Morecambe Offshore Windfarm: Generation Assets Pre-Examination Documents

Response to Acceptance Section 51 Advice

Section 51 advice following issue of decision to accept the Morecambe Offshore Windfarm Generation Assets Development Consent Order application (EN010121) for examination

Figure: 7.1      Drawing No: PC1165-RHD-ES-OF-DR-Z-0008

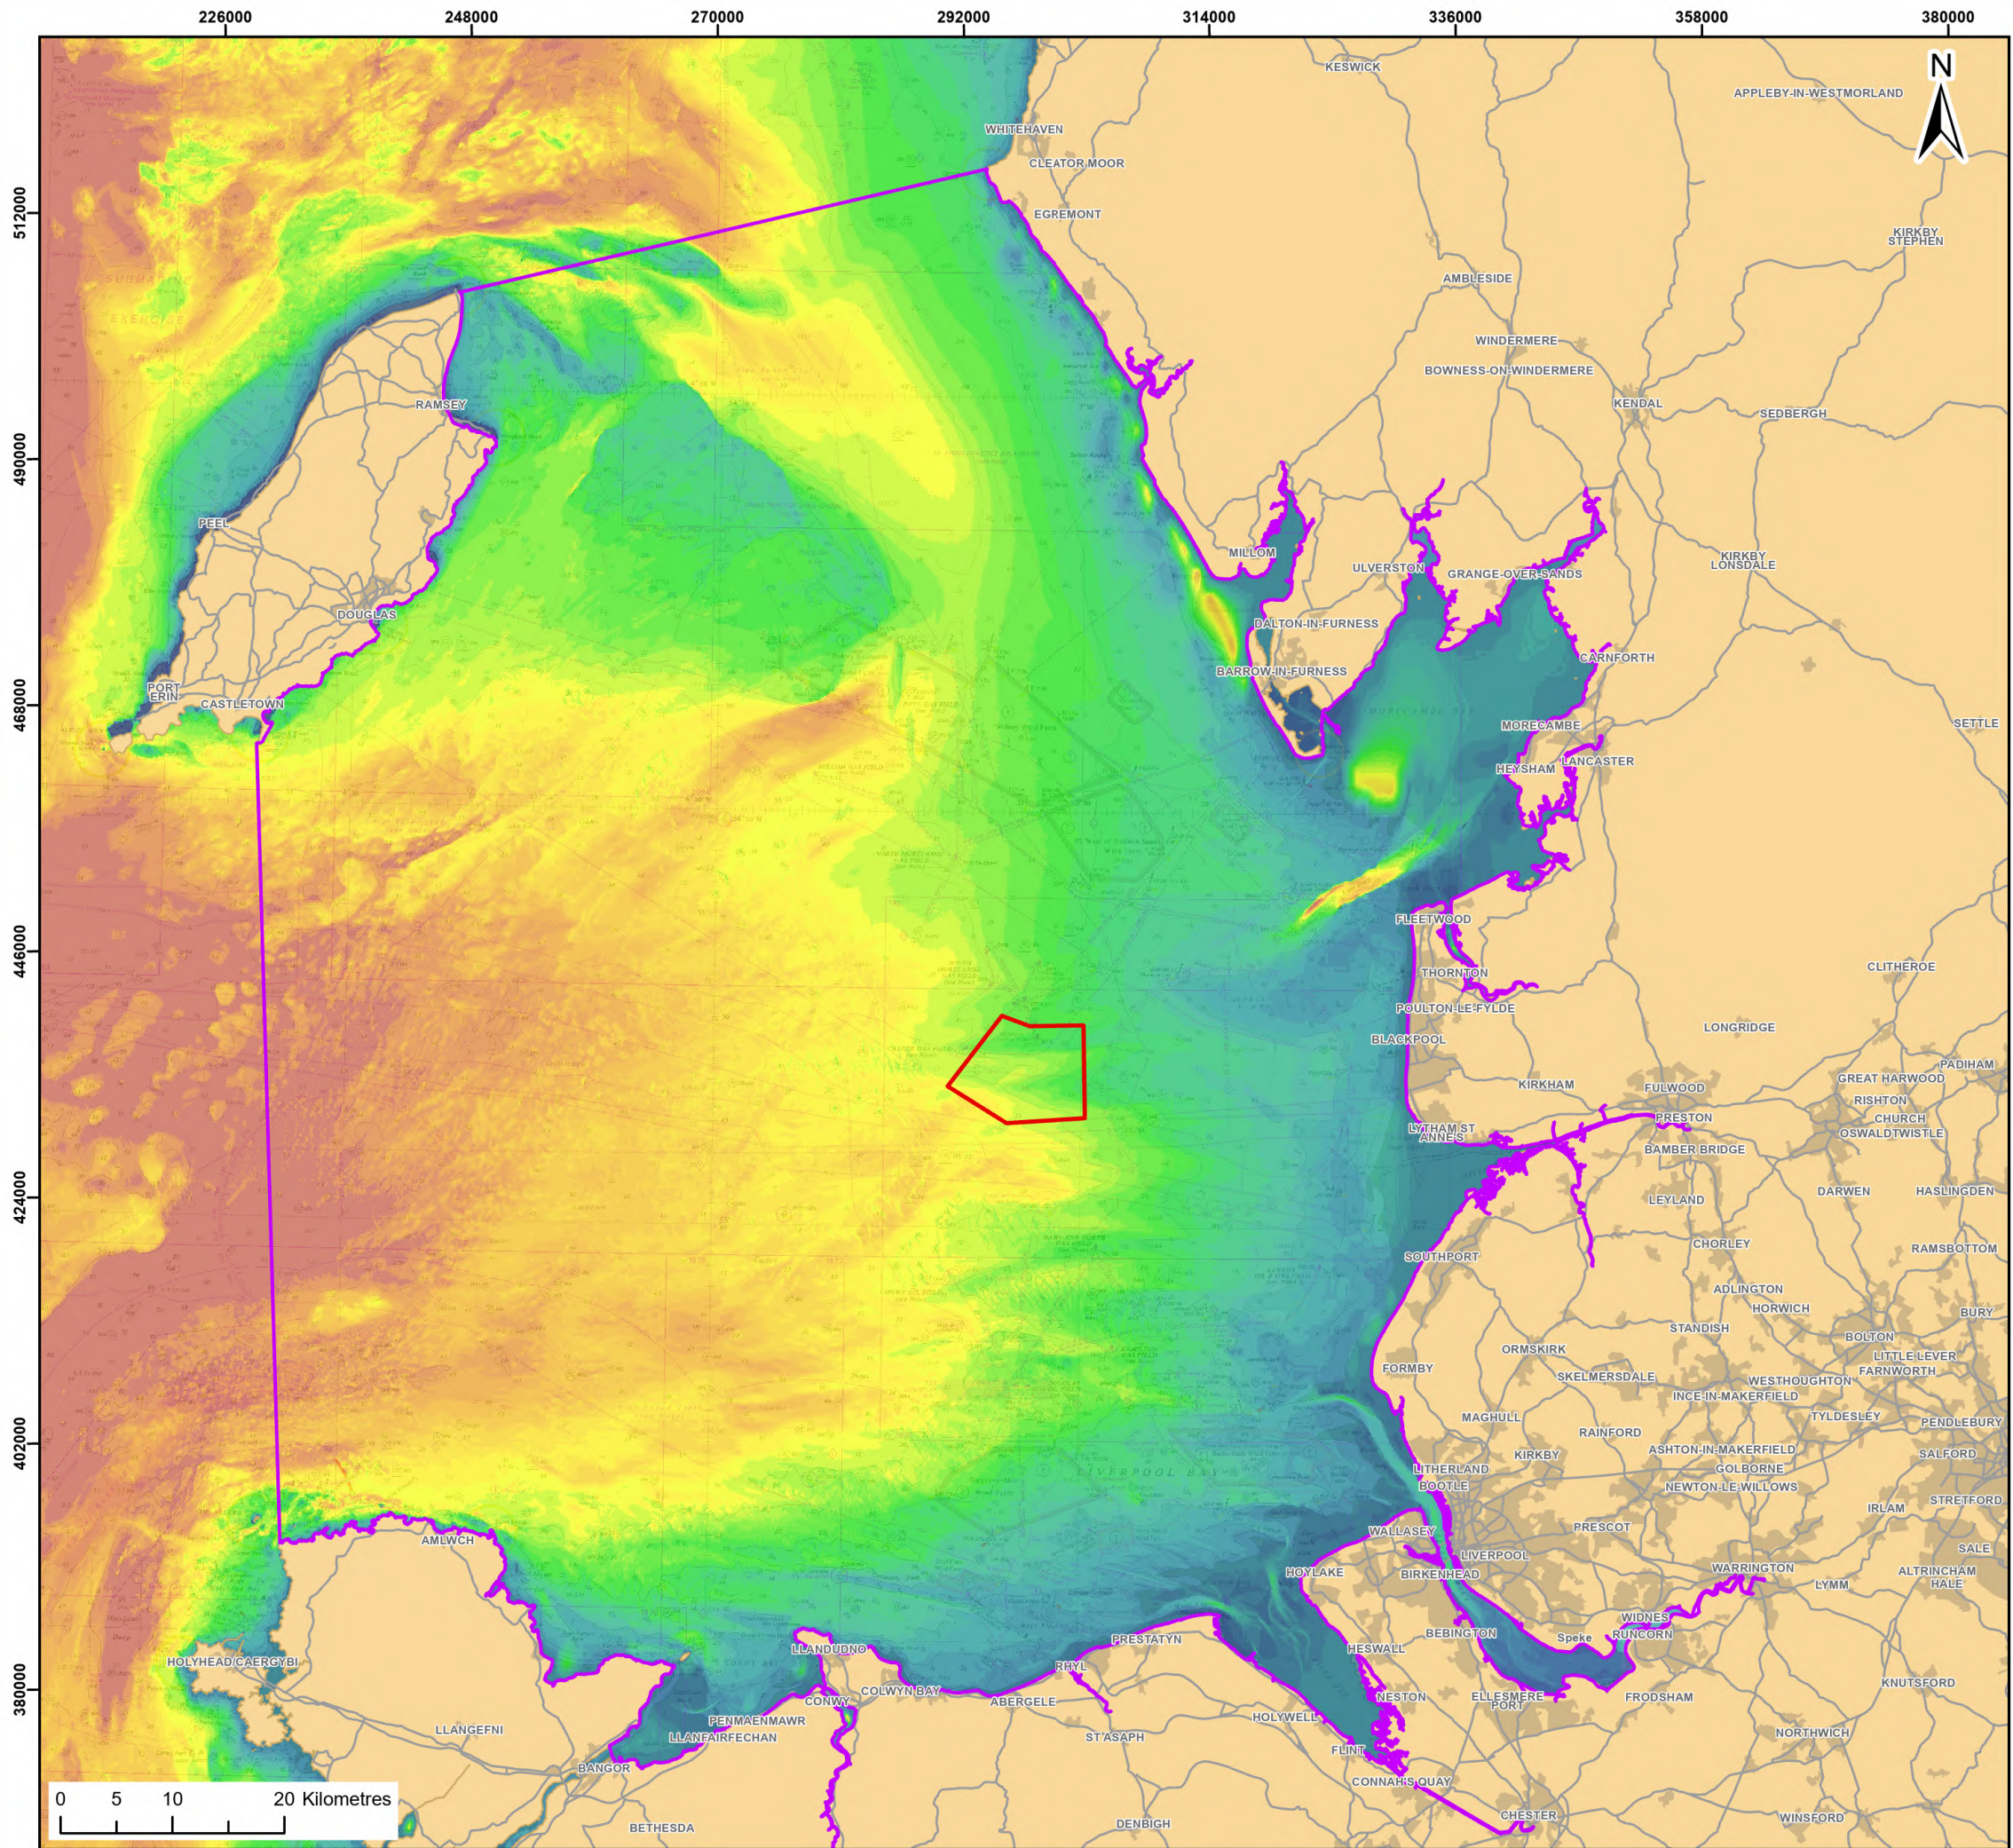
In addition, correspondence was received from the Planning Inspectorate on the 23 July 2024 in line with the Rule 4 letter regarding an amendment to the key in Figure 7.1 (packaged within Document Reference 5.3.7; [APP-091](#)). A key for the bathymetry data has been added and this is provided as a Rev 02.
